Bathrooms	<input type="checkbox"/> Denied	Use Group: 5-1	Type: 2
Proposed Project Description: Selective demo of existing space. Interior fit-up for storage units & ADA compliant Bathrooms			<i>See Conditions</i> Signature: <i>Carca Case</i>	<i>DBL-2003</i> Signature: <i>JMB 10/8/08</i>	
			PEDESTRIAN ACTIVITIES DISTRICT (P.A.D.) Action: <input type="checkbox"/> Approved <input type="checkbox"/> Approved w/Conditions <input type="checkbox"/> Denied Signature: _____ Date: _____		
Permit Taken By: Idobson	Date Applied For: 07/15/2008	Zoning Approval

Dept: Zoning **Status:** Approved with Conditions **Reviewer:** Marge Schmuckal **Approval Date:** 07/23/2008
Note: **Ok to Issue:**

RE: Partial Site Plan Exemption, 217 Read Street - Self Storage

READ STREET SIDEWALK IMPROVEMENT PLAN
 OF
READ STREET SELF STORAGE
 217 READ STREET
 PORTLAND, MAINE
 FOR:
GRONDI PROPERTIES LLC.
 11 BARTLETT ROAD
 GORHAM, MAINE 04038

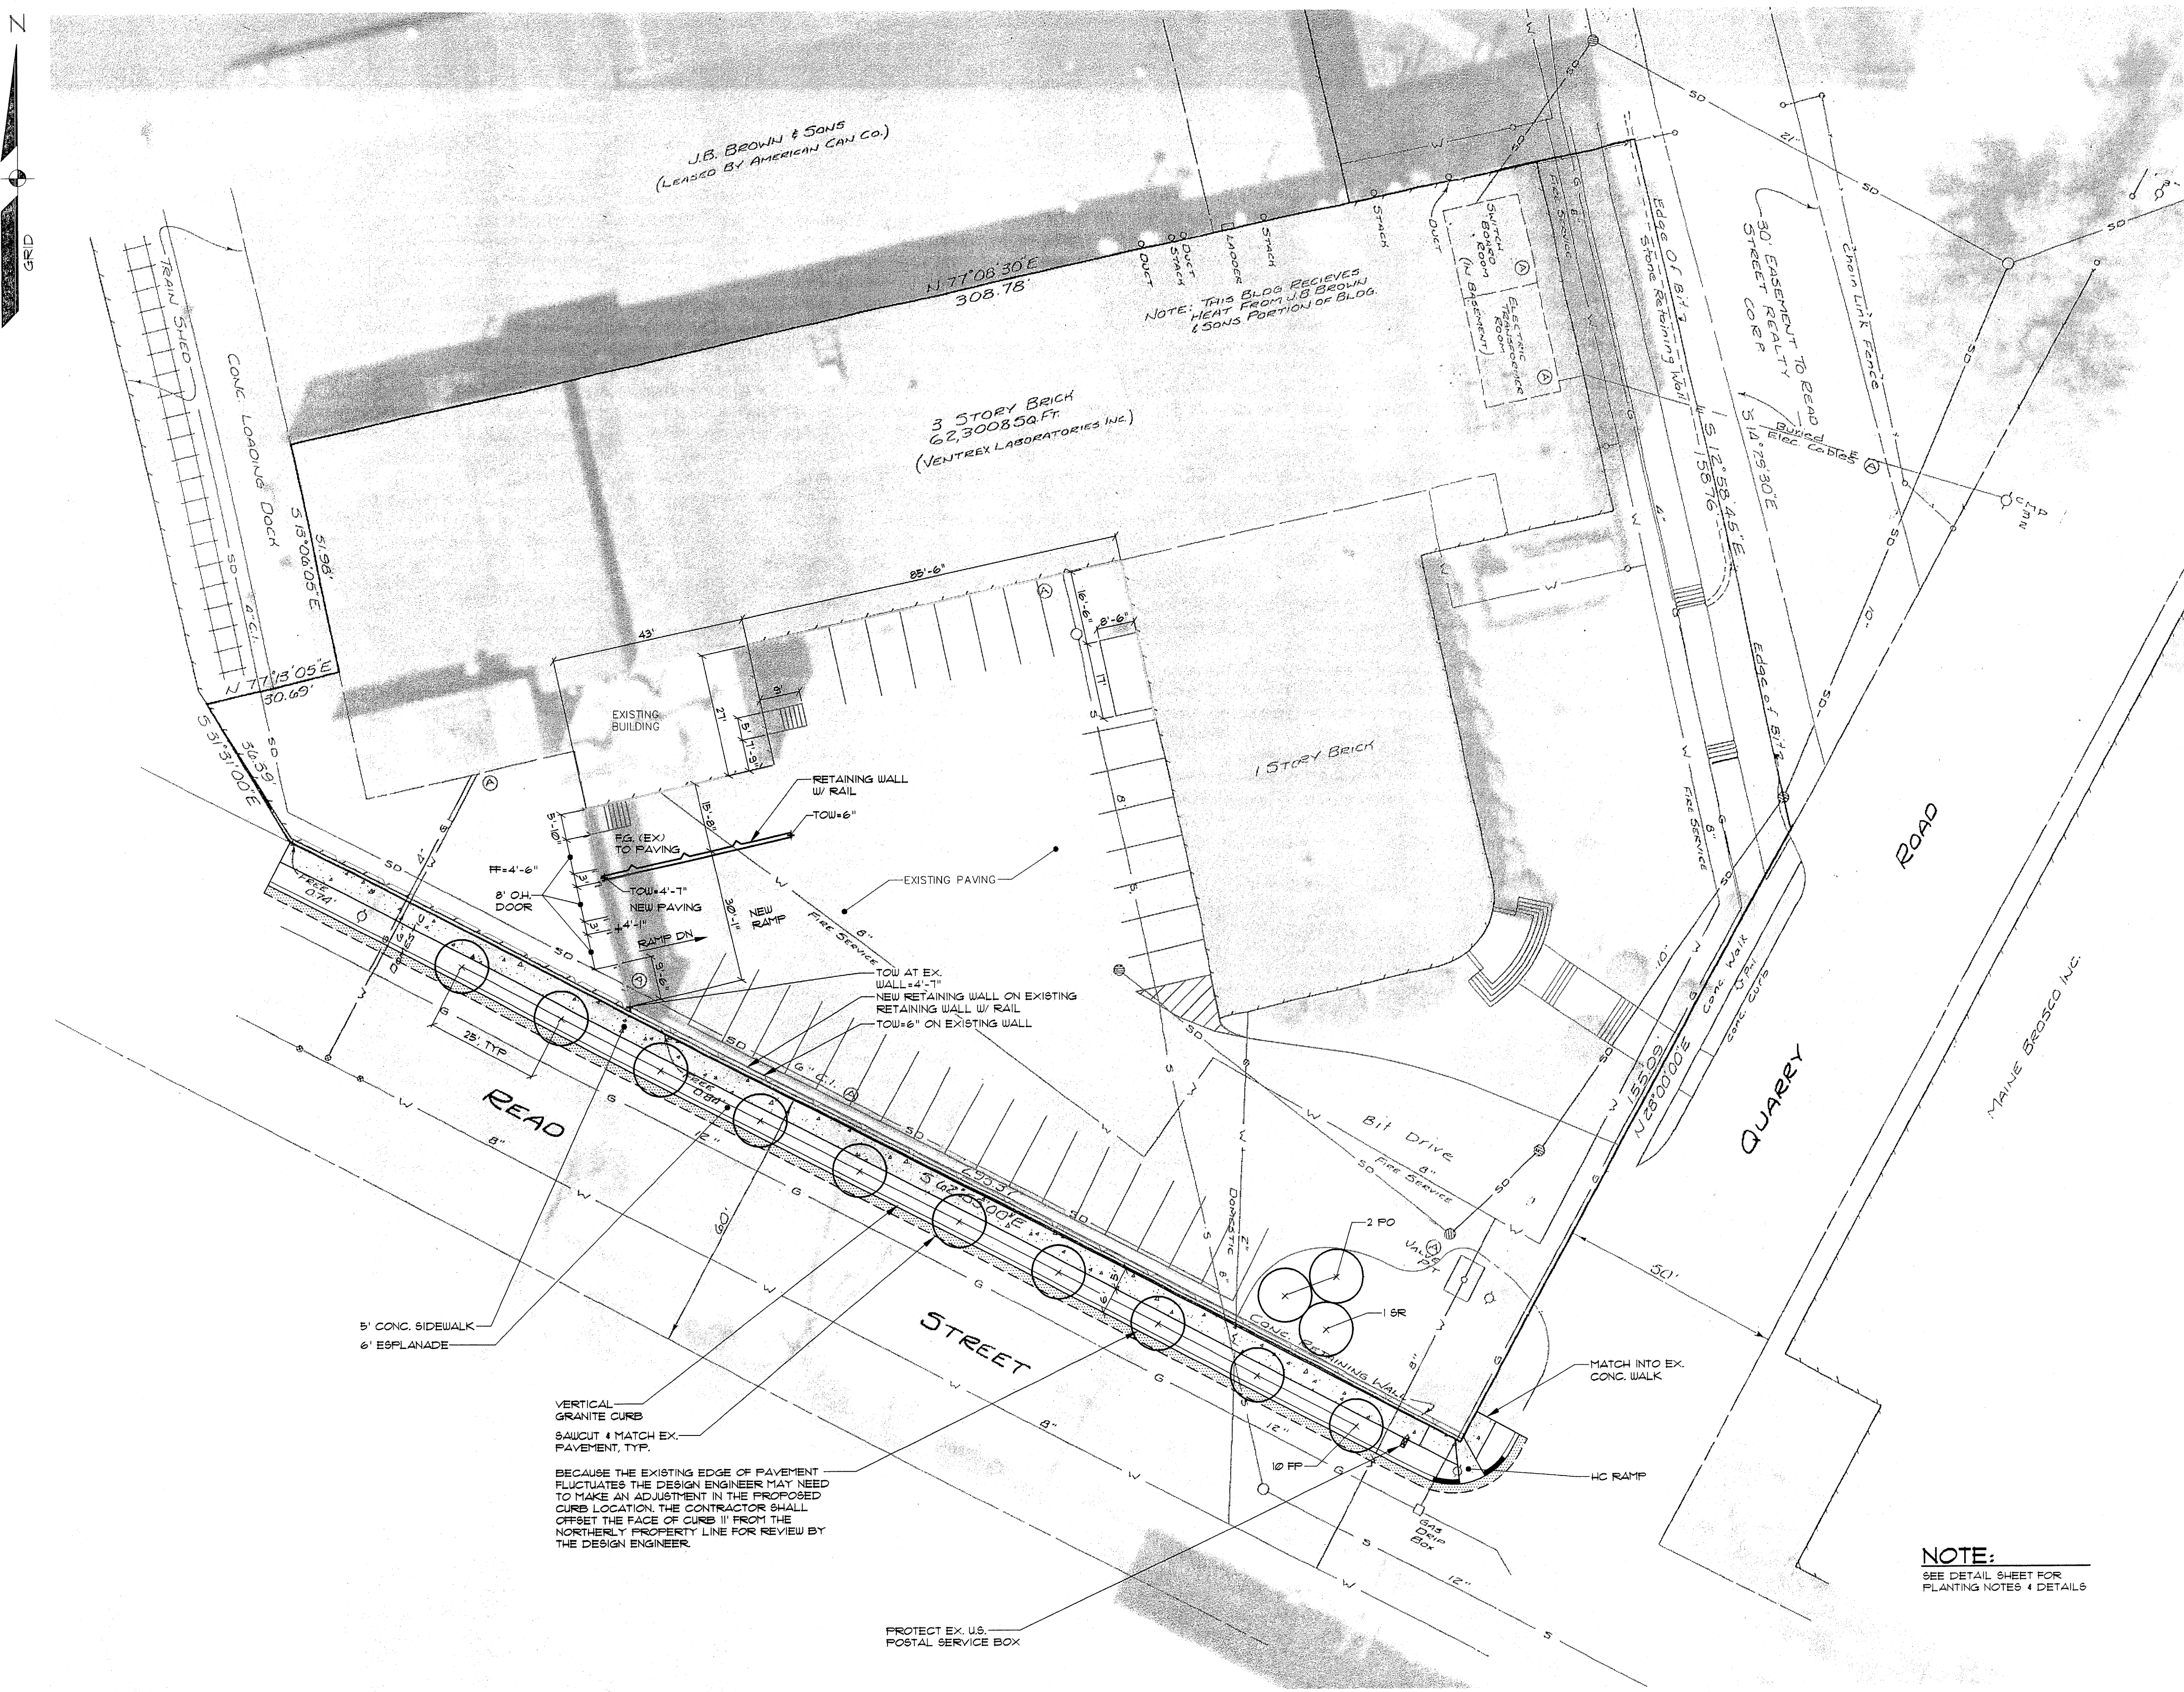
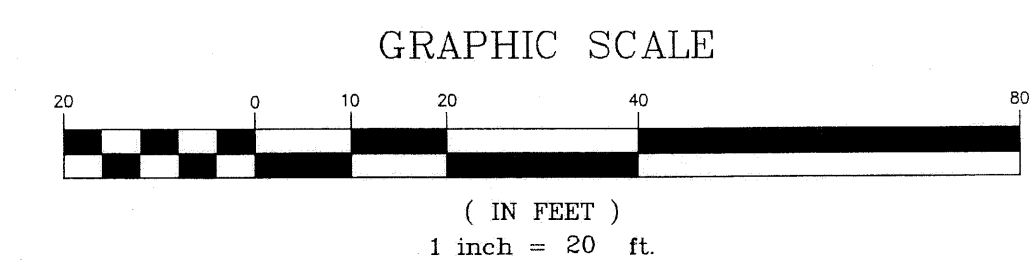
The Planning Division received your letter and site plan, dated June 3, 2008, requesting a partial exemption from site plan review. Your partial exemption has been granted with the condition that the following improvements be installed as specified on the submitted site plan:

1. Install granite curb and sidewalk along the Read Street frontage.
2. Install ten (10) street trees (green ash) along Read Street frontage.
3. Install additional landscape screening to buffer loading dock area.
